**HORSLEY DRIVE BUSINESS PARK – STATE SIGNIFICANT DEVELOPMENT APPLICATION
17161650**

This letter forms a response to the RTS for SSD 17161650.

EXIT

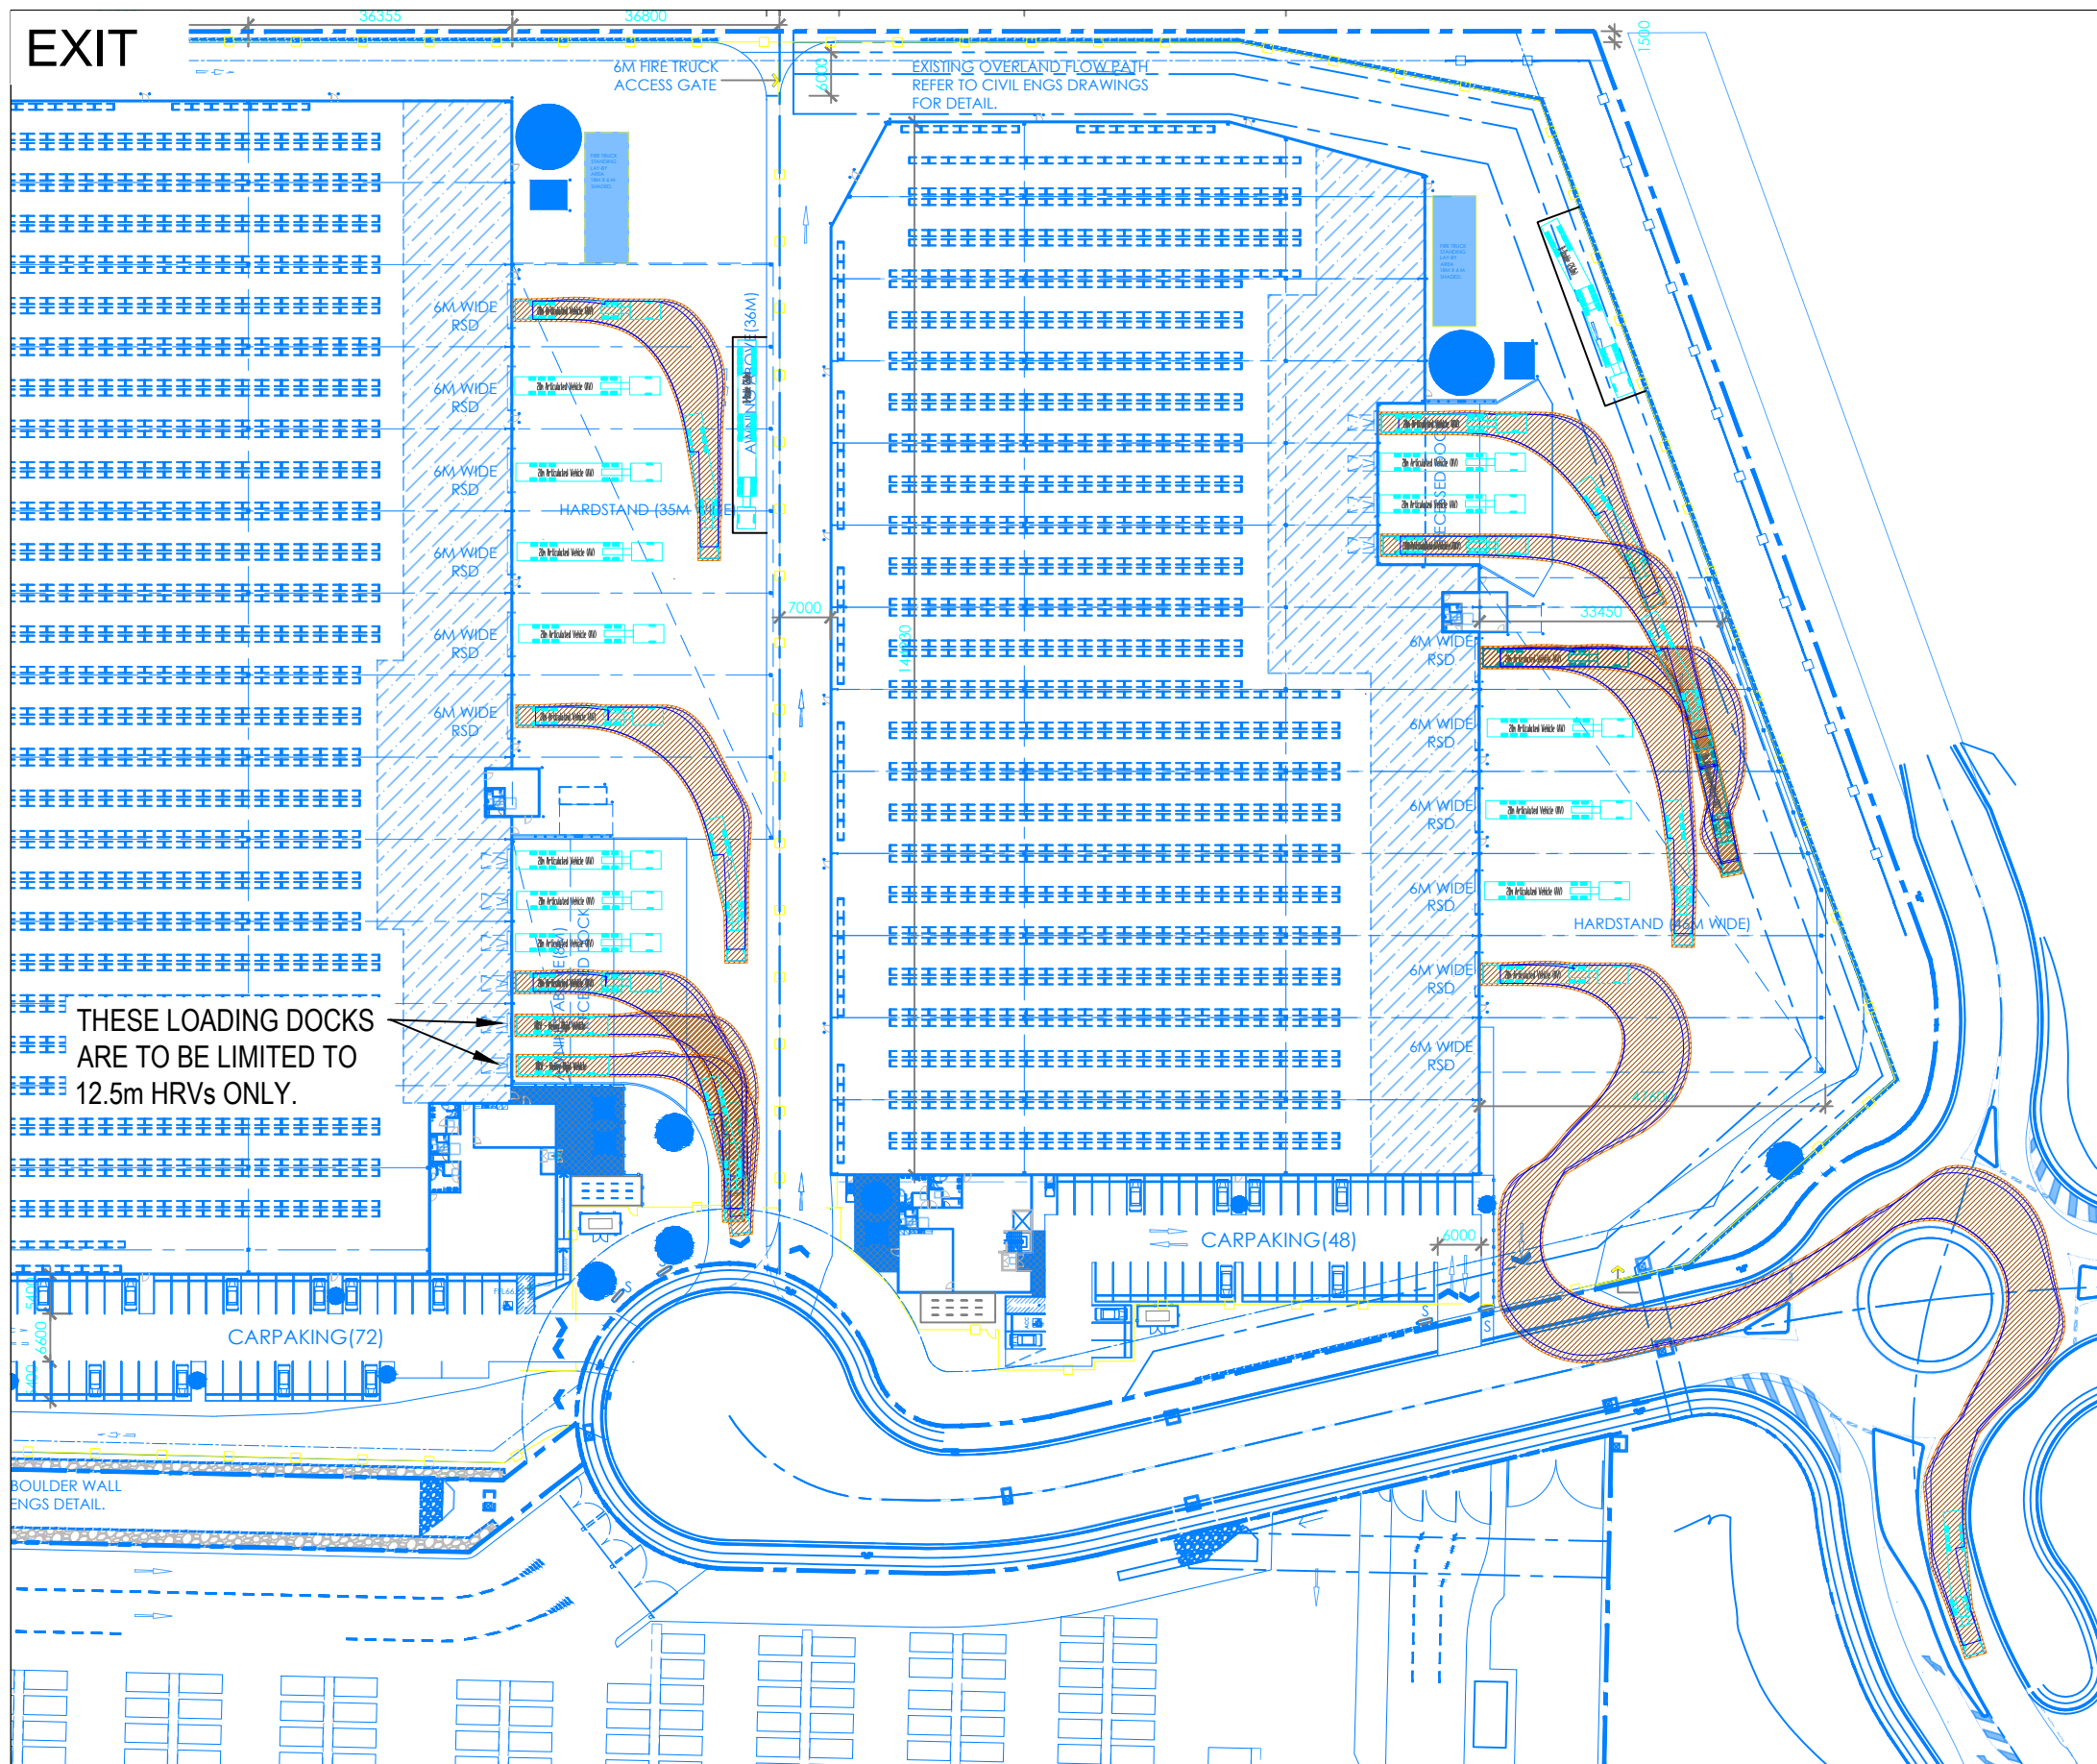
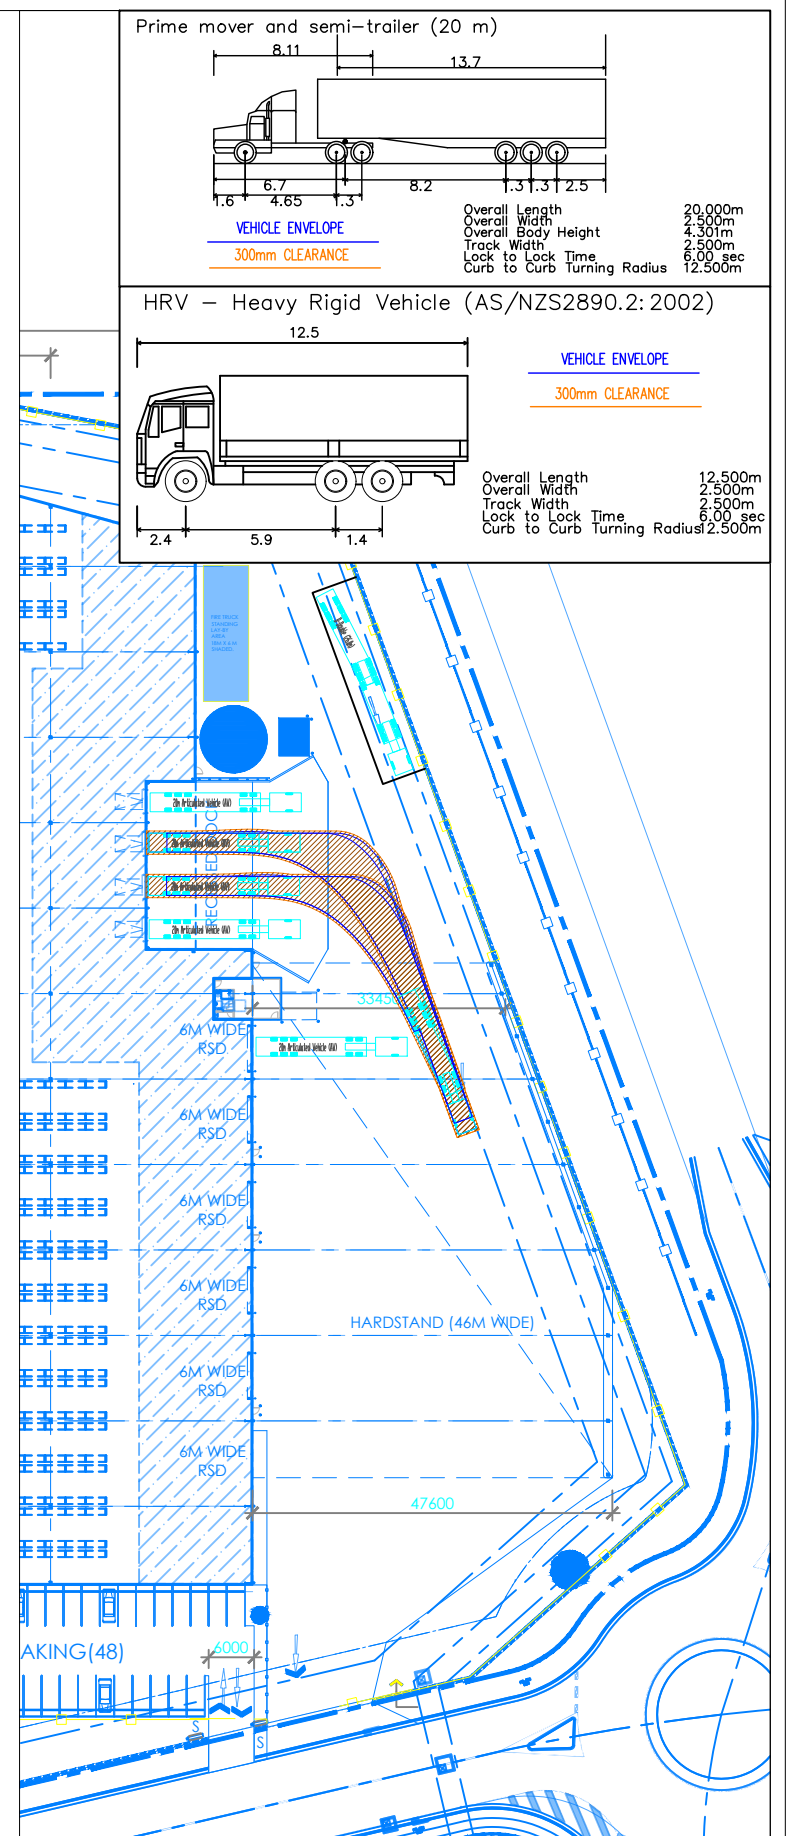
- **Warehouse 3 Turning Movements** – The SSDA shall be conditioned so that vehicles exiting warehouse 3 shall be limited to left out only as a right turn movement exiting the warehouse. Should vehicles wish to return to the Estate Road or the sites the roundabout at Cowapasture Road provides them with the opportunity to do so.

In addition, the applicant shall review the driveway width of warehouse 3 to accommodate 26m B-Double vehicle left turn movements. Based on the applicant's swept path diagram, vehicles turning left out of this driveway would encroach onto the footpath area of the Estate Road. The applicant shall provide Council with a driveway splay design that demonstrates B-doubles can make a left turn movement without impacting the footpath

Drawing Title
SITE AND GROUND FLOOR PLAN
Project Number
CH HDBP
Drawing Number
DA - 03

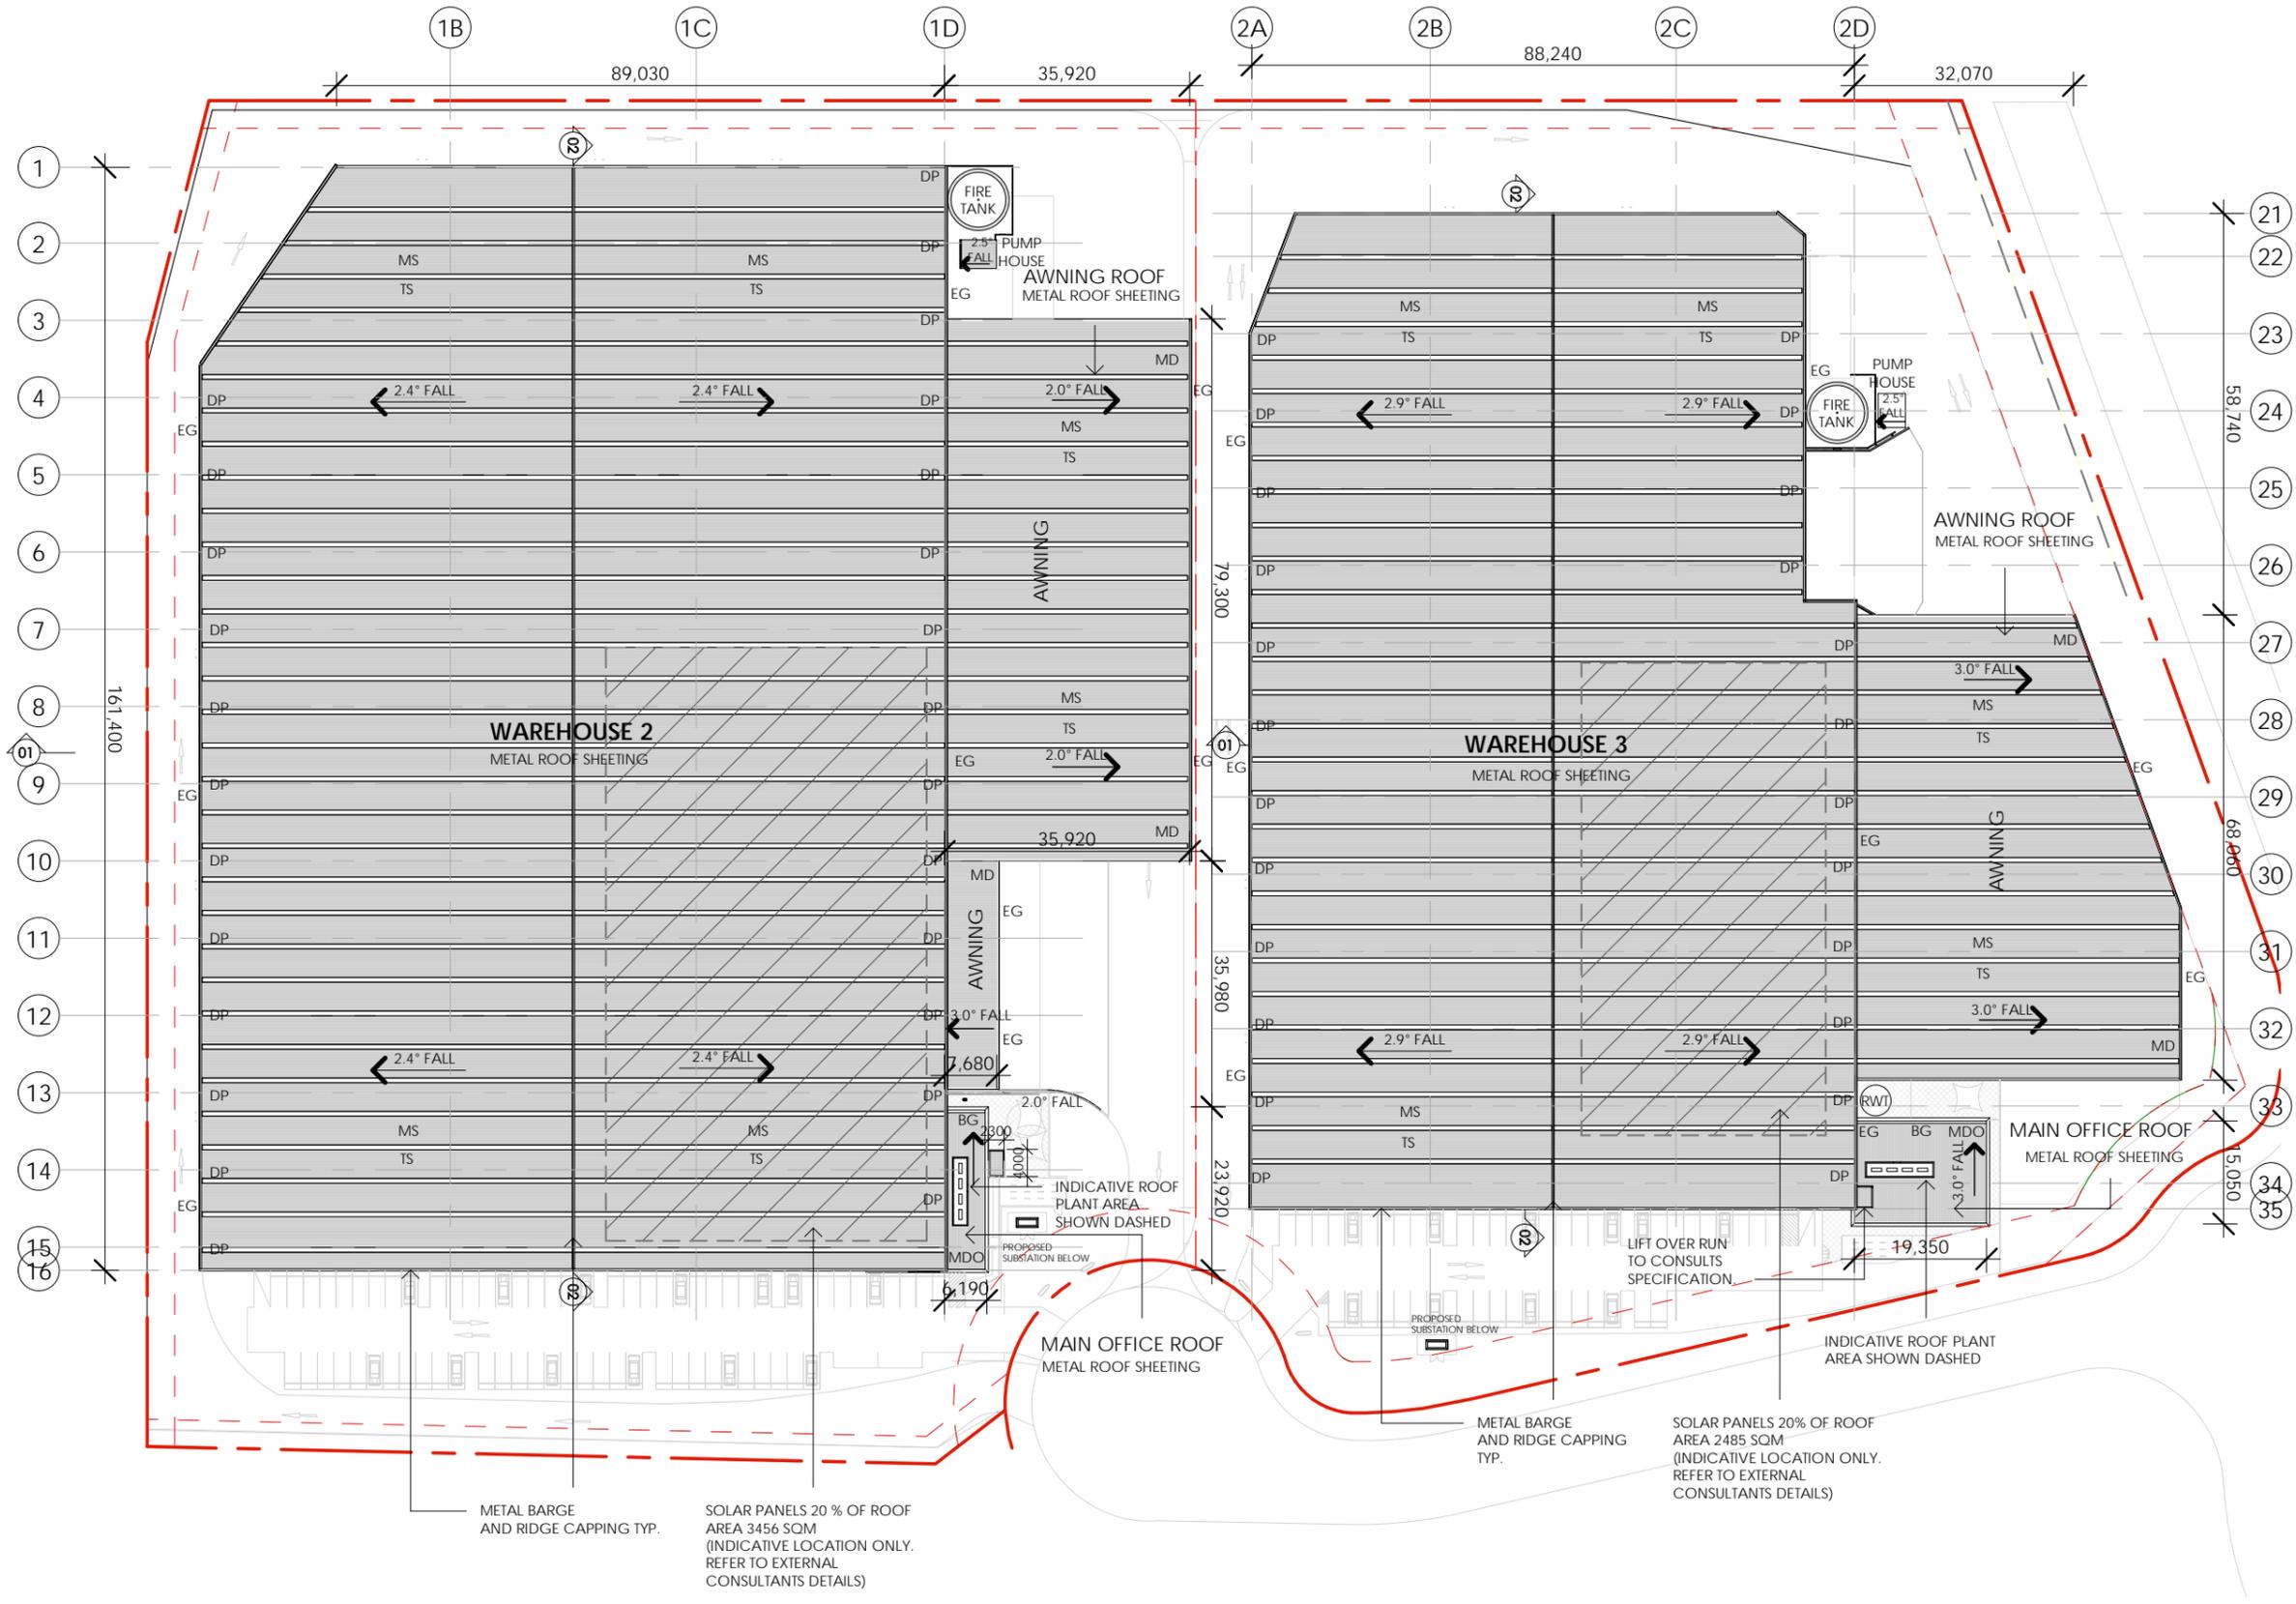
- **Appendix A - Operational Traffic Flows** show information on traffic movements into and out of warehouse 2 and warehouse 3. The location of the "Site" for the development should be clarified and it should be shown on the architectural plans. Please find below the table extracted from the report.

- The Proposed driveway exit at warehouse 3 conflicts with an existing kerb inlet pit. A Section 138 Approval from Council will be required for any changes to the kerb inlet pit. This can be conditioned.
